Section 75W to Project Approval (MP10_0050)

Westmead Millennium Institute, Westmead Health Campus

Submitted to Department of Planning and Infrastructure
On Behalf of Westmead Millennium Institute for Medical Research

September 2013 ■ 13254

FLOOR PLAN
LEVEL 00 - LOWER GROUND

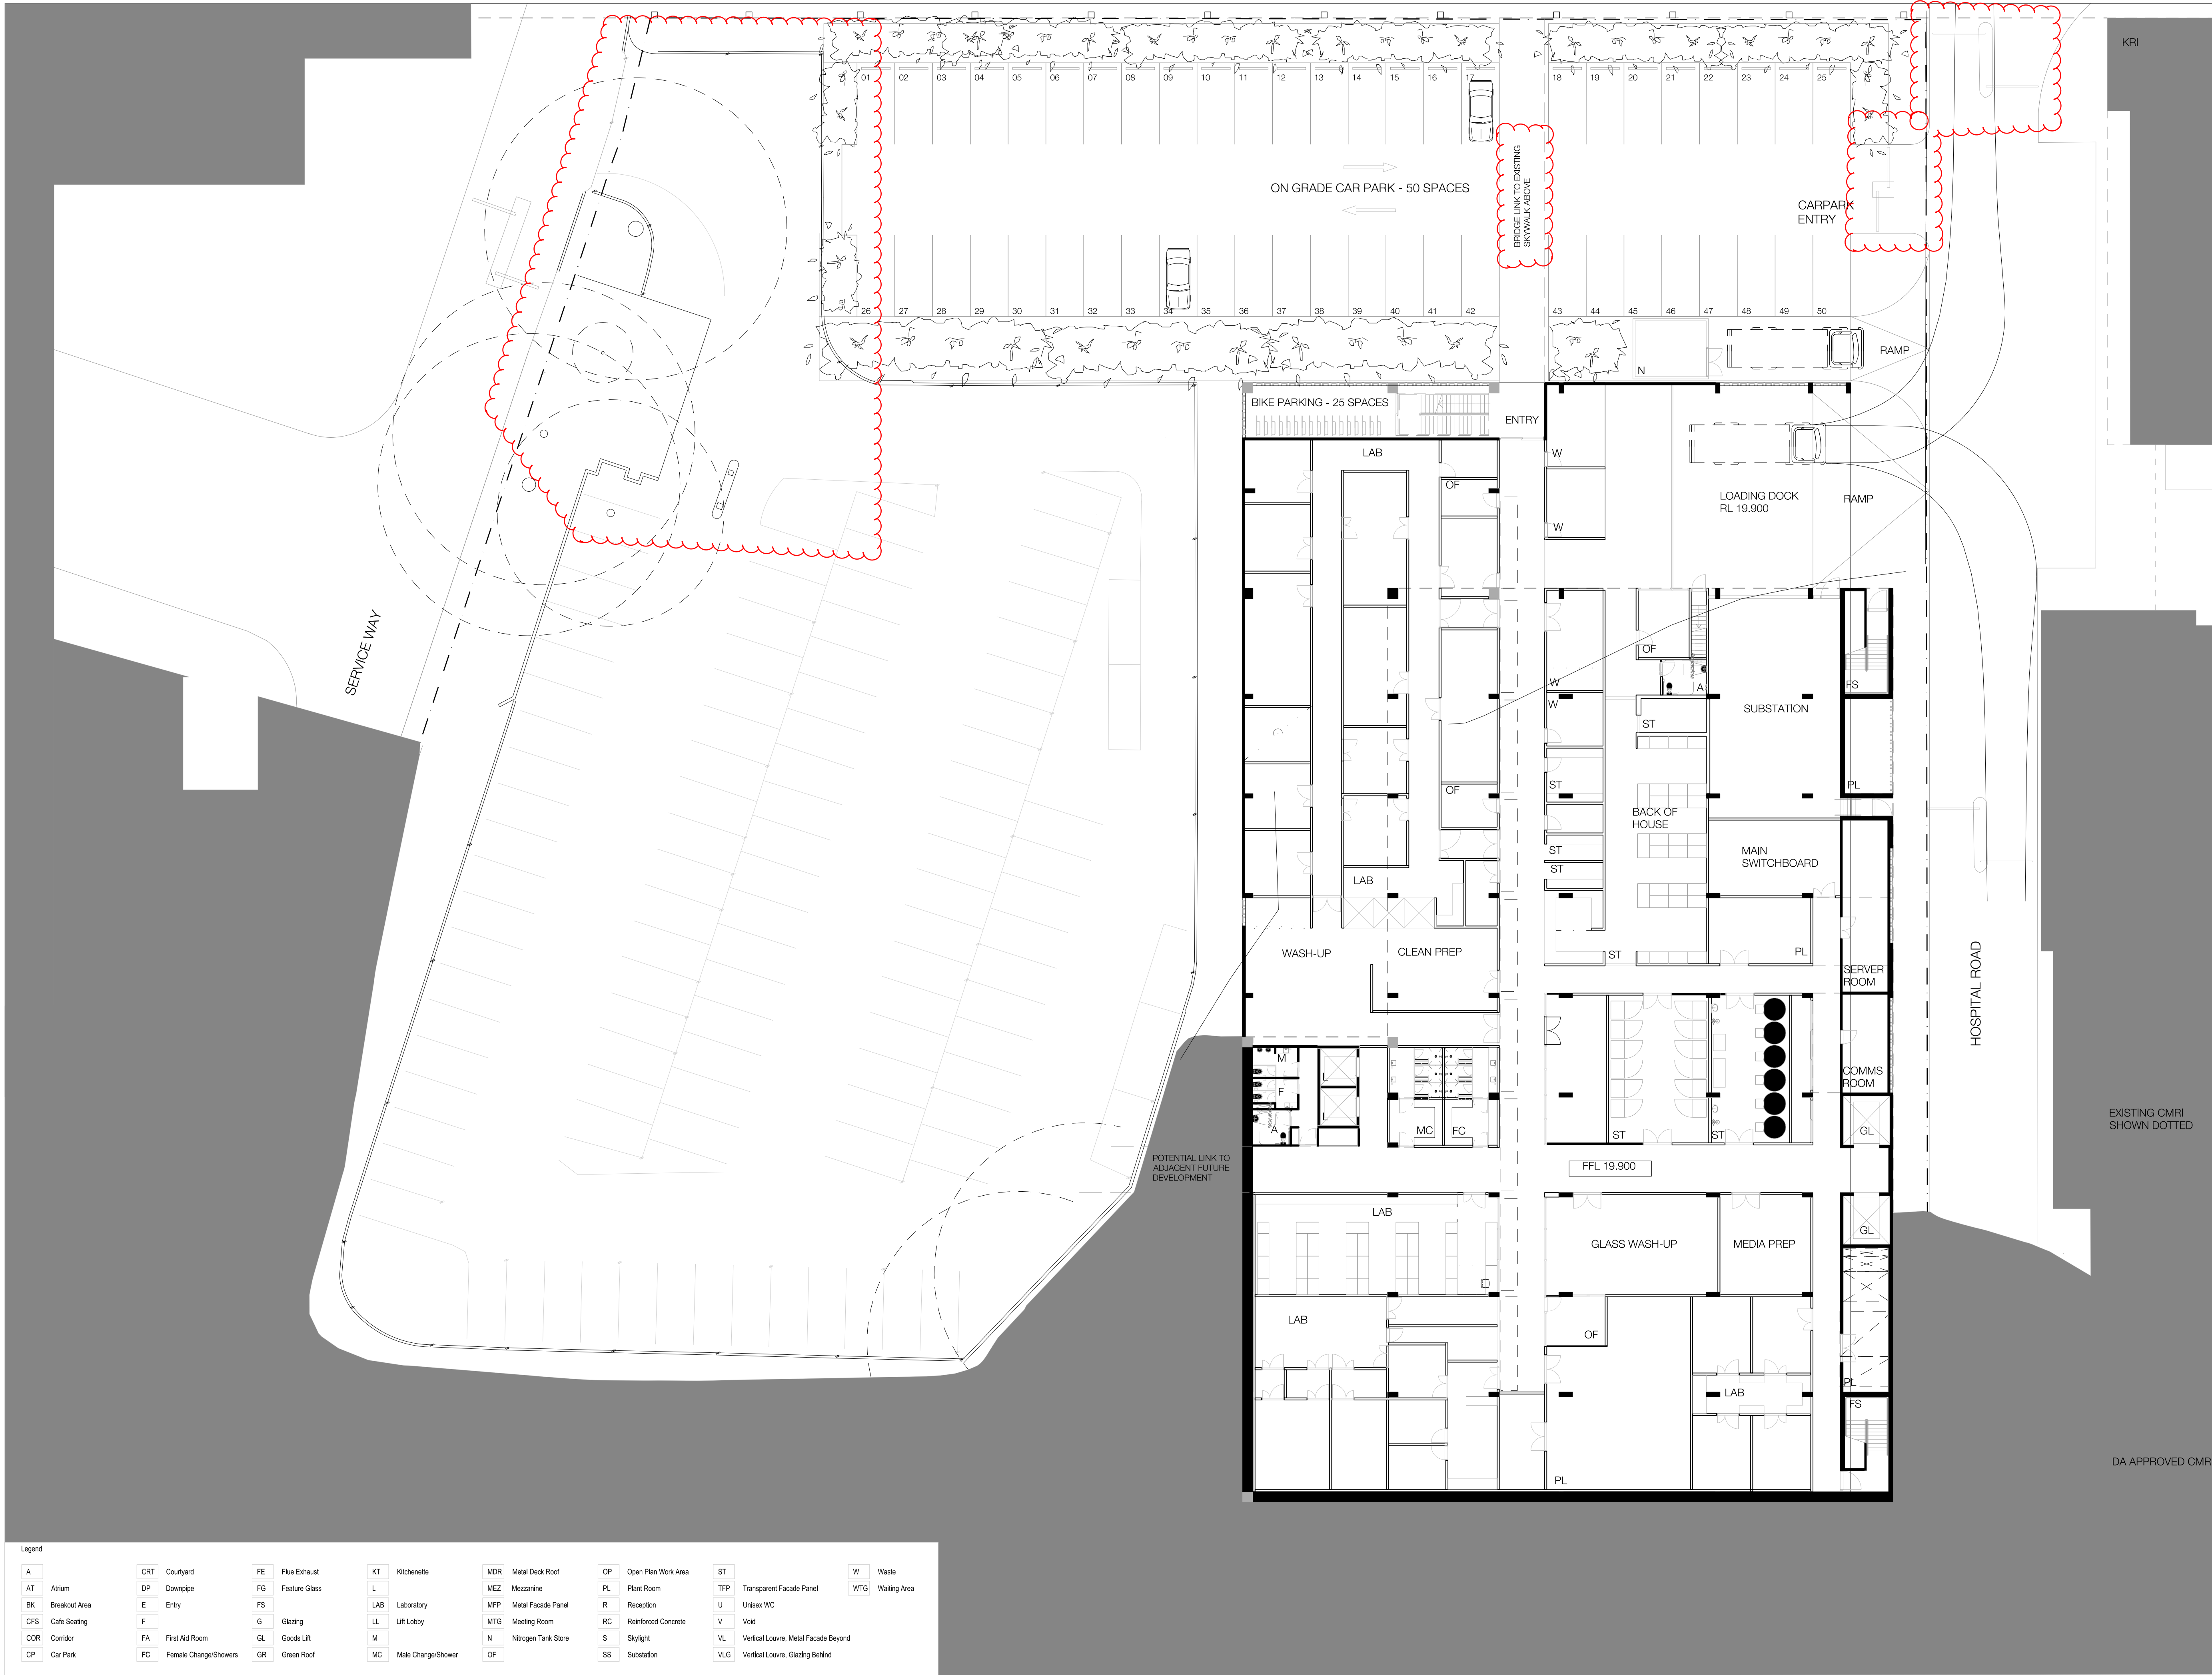
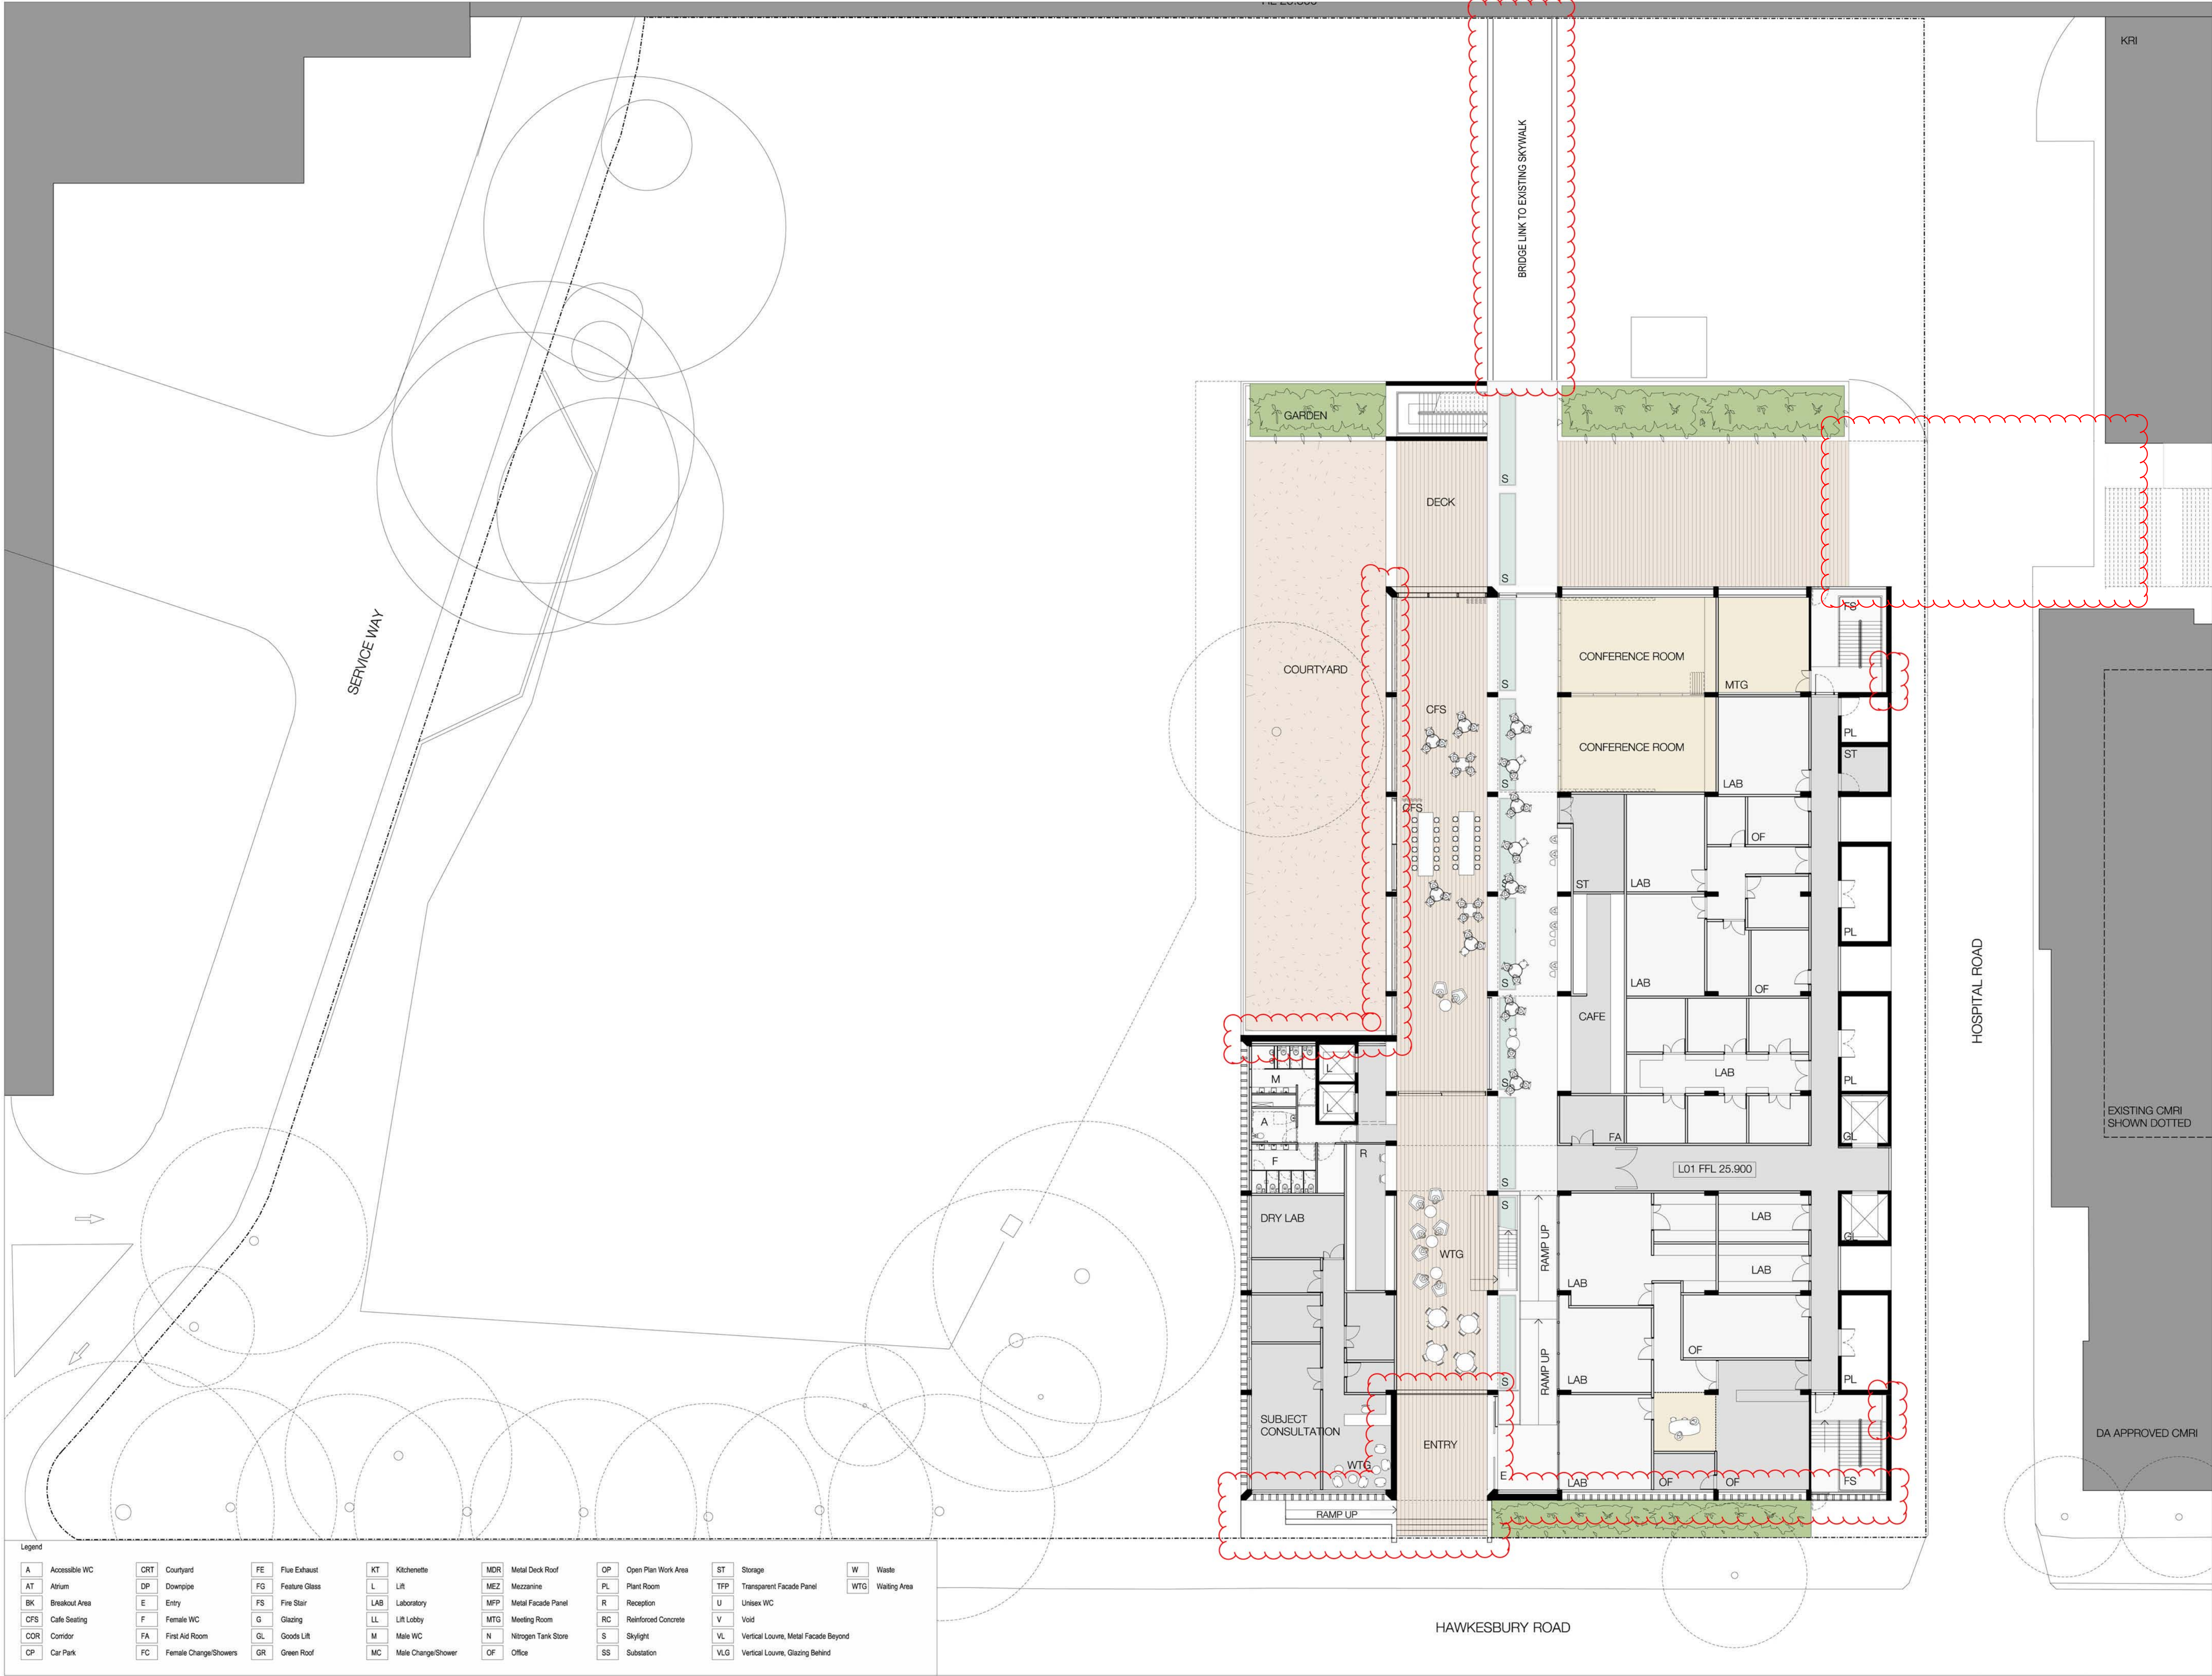
Since the original access arrangements were devised for the at grade car parking serving WMI, it has now become evident that there are a number of issues related with this option.

Following an analysis of alternative options, Cattell Cooper advise that a preferred option for access/egress for WMI staff and visitors is from Hawkesbury Road via Hospital Road adjacent to CMRI. This preferred option has been reflected within the revised architectural plans include at **Appendix A**.

As part of design development it has become evident that the difference in levels between the Hawkesbury Road footpath and the main building entrance are such that it warrants the provision of a new ramp access arrangement to be provided.

Detailed survey of the levels demonstrate that the original design intent incorporating the 1 in 20 ramped entry starting from the western edge of the footpath cannot be accommodated. An alternative design involving extending the ramp across the footpath to the eastern edge (i.e. the curb line) was considered however given objection raised by Parramatta City Council (on the basis that the crossfall of the footpath would exceed 1 in 40 gradient) it has not been progressed.

Accordingly, a revised compliant solution is now being proposed for the main entrance that comprises a 1 in 40 wheelchair accessible ramp running north-south along the south-eastern corner of the building with a complementary adjacent stepped connected between the footpath and the main entrance levels.
